Your Ref: OWPC20670
Our Ref: EG/67/18/HH 07-09-2018
Please ask for:
Stuart Corbey

Part two storey part single storey rear extension, increase in garage height and conversion into additional room

Trebarwith Cottage Barnham Road Eastergate

PROPOSED ELEVATIONS AND FLOOR PLANS SCALE 1:100

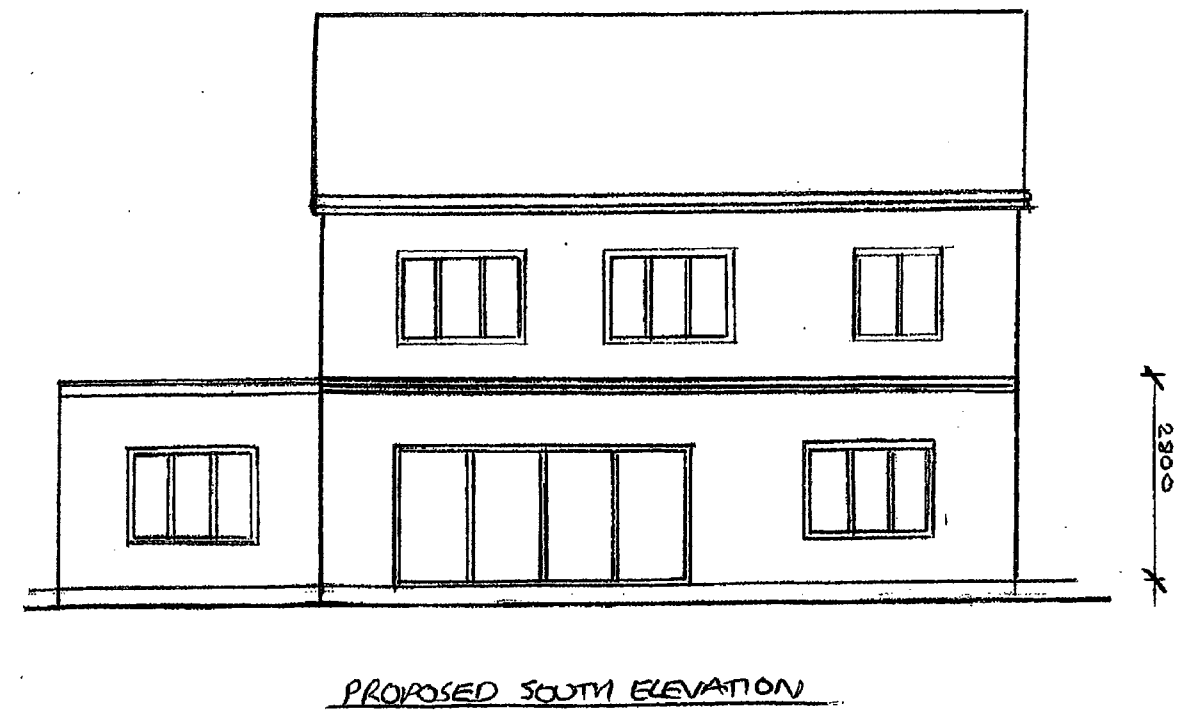
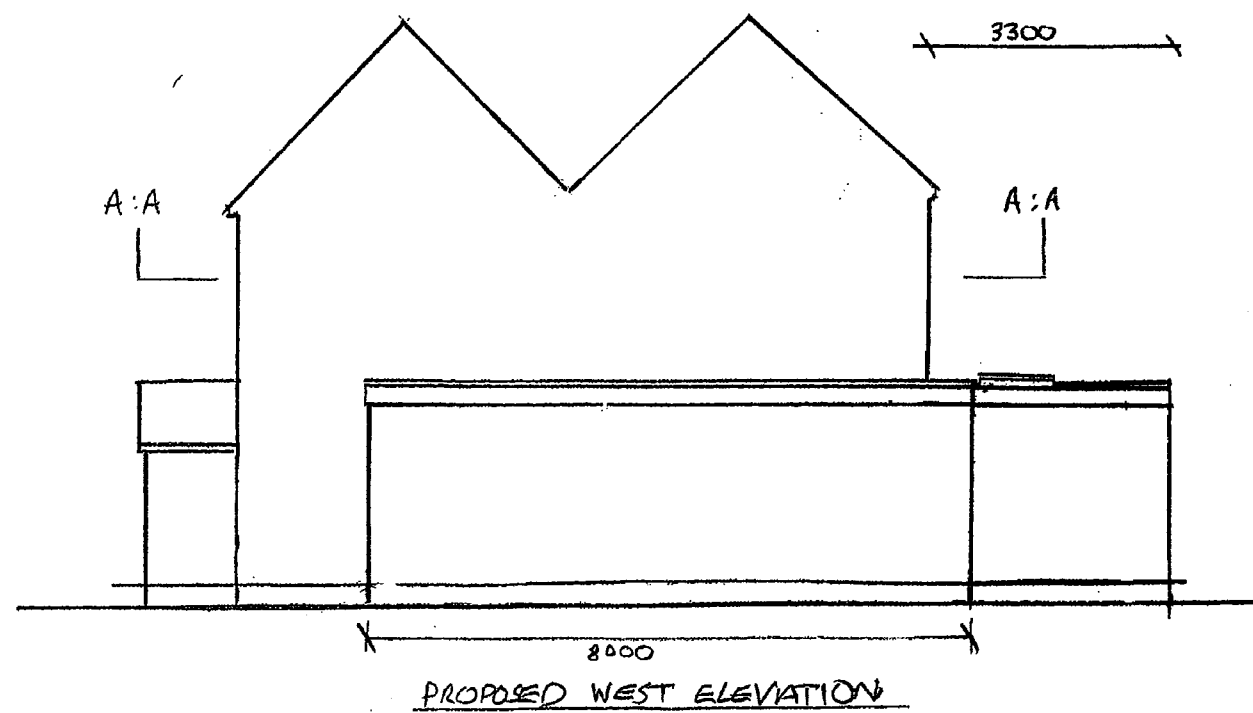
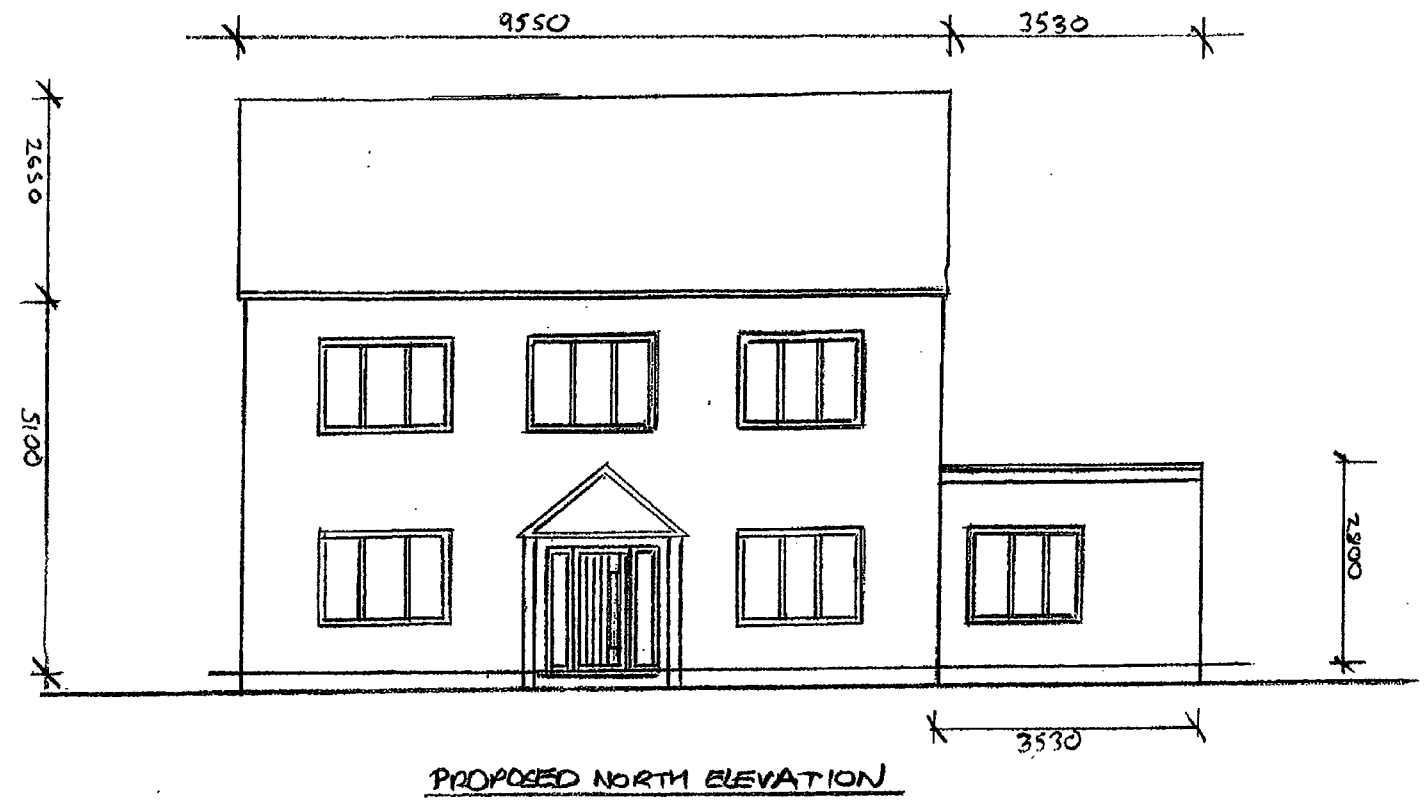
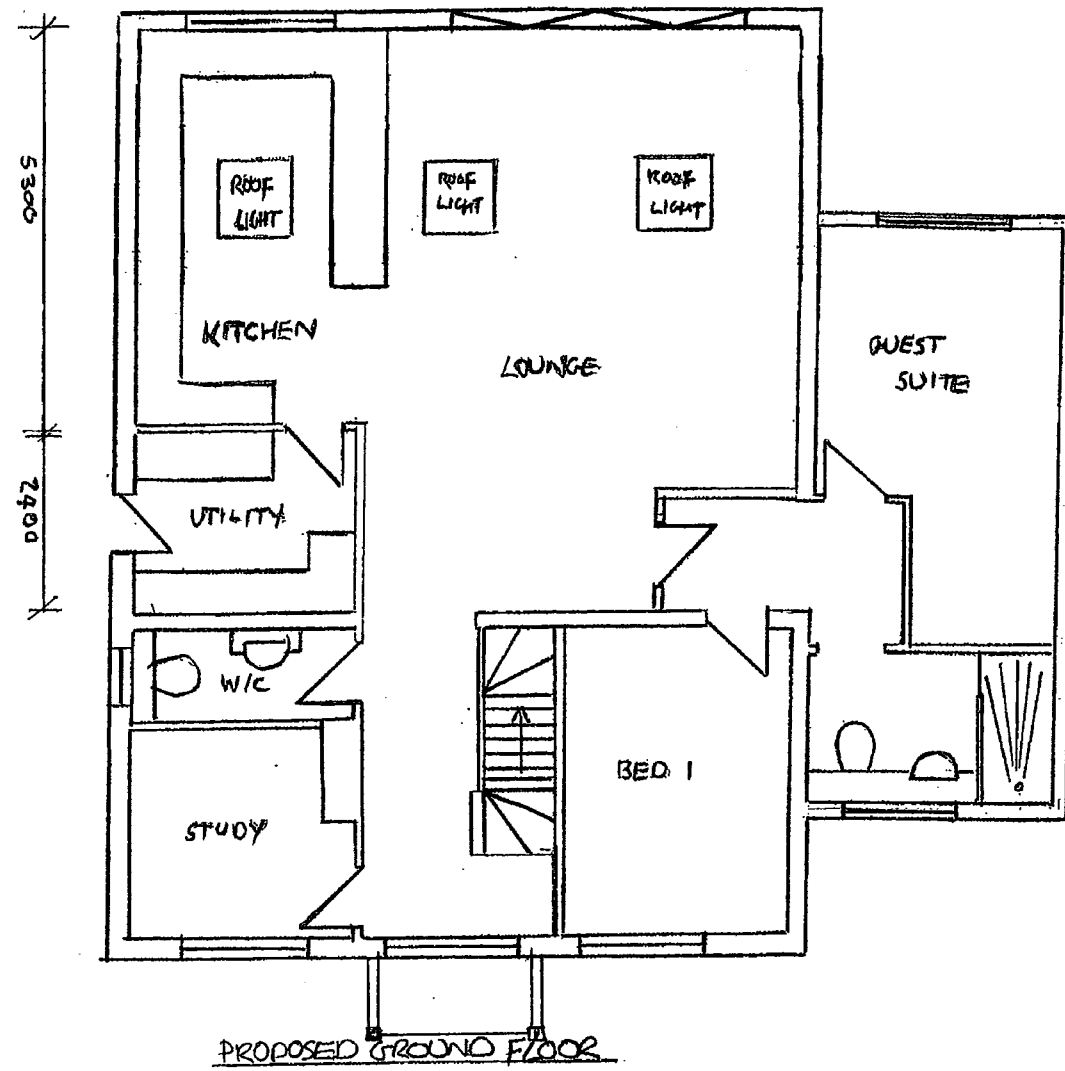
By my calculations, from the dimensions shown on the submitted drawings - although these appear to be an inconsistent mix of internal and external - the existing gross external floor space is 124.73 sq m including the garage. In comparison the proposed space is an additional 116.5 sq m.

So the increase is 93.4% which is almost double what is generally considered proportionate.

This excessive increase in size also means that the building is out of keeping with both of its neighbouring properties and overshadows my property in particular.

According to your standards for parking provision for residential development the proposed increase in the size of the building increases the requirement for car parking spaces to three. Presumably this can only be accommodated at the front of the house but nothing is shown on the submitted drawings to indicate the feasibility or practicality of this. Surely you should require details to be submitted?
